30 July 2021

**RESPONSE TO SUBMISSIONS  
FORT STREET PUBLIC SCHOOL, SECTION 4.55(2) MODIFICATION APPLICATION (SSD-10340)**

VIEWPOINT 4

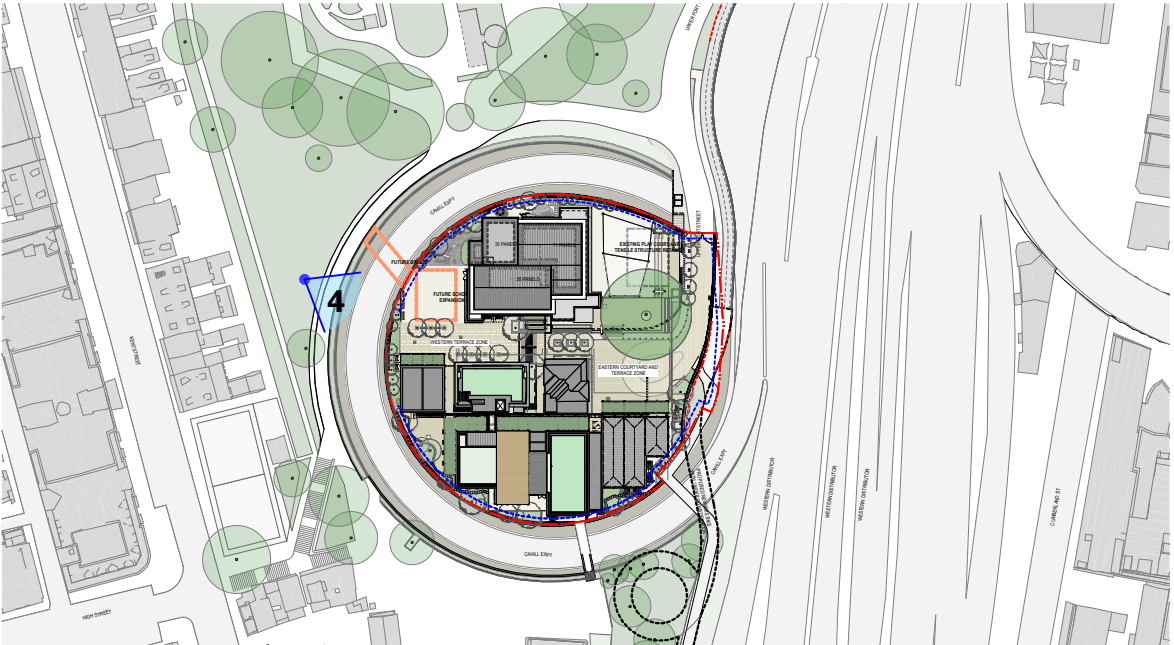
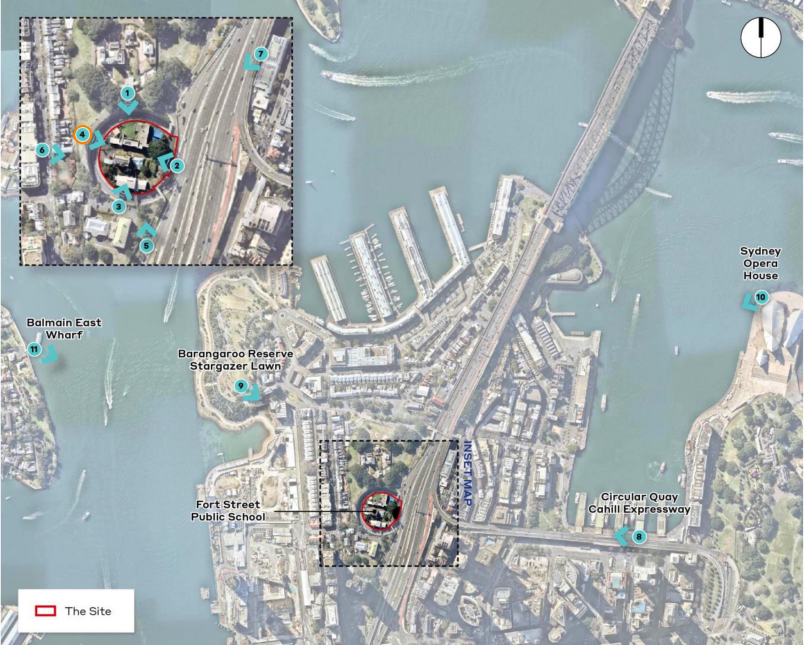
When viewed from Agar Steps to the west (**Figure 2**), the additional height to Building J will only have a very minor visual change from the approved SSD and does not obscure any iconic views or views to heritage items.

VIEWPOINT 7

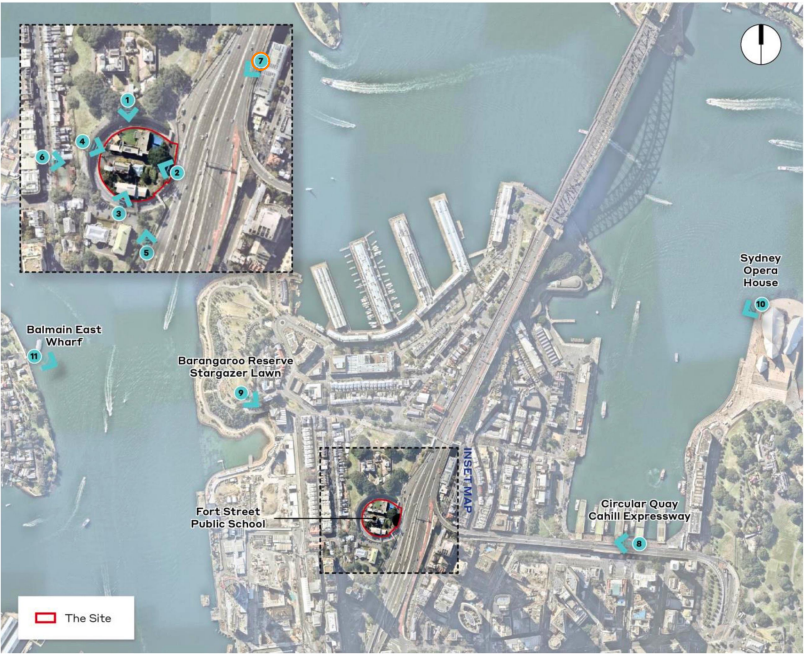
When viewed from the Harbour Bridge Cahill Expressway, the additional height of Building J will be concealed behind the Fig Tree and will not be visible. This is demonstrated in **Figure 3**, with the outline of Building J shown dashed behind the tree for clarity. It is also noted that views to the site from this north-east perspective on the Harbour Bridge are already dominated by the backdrop of multi-storey buildings of significant height to the south (including Barangaroo and Crown). Within this city context, the FSPS buildings present as a comparatively low density and low scale development.
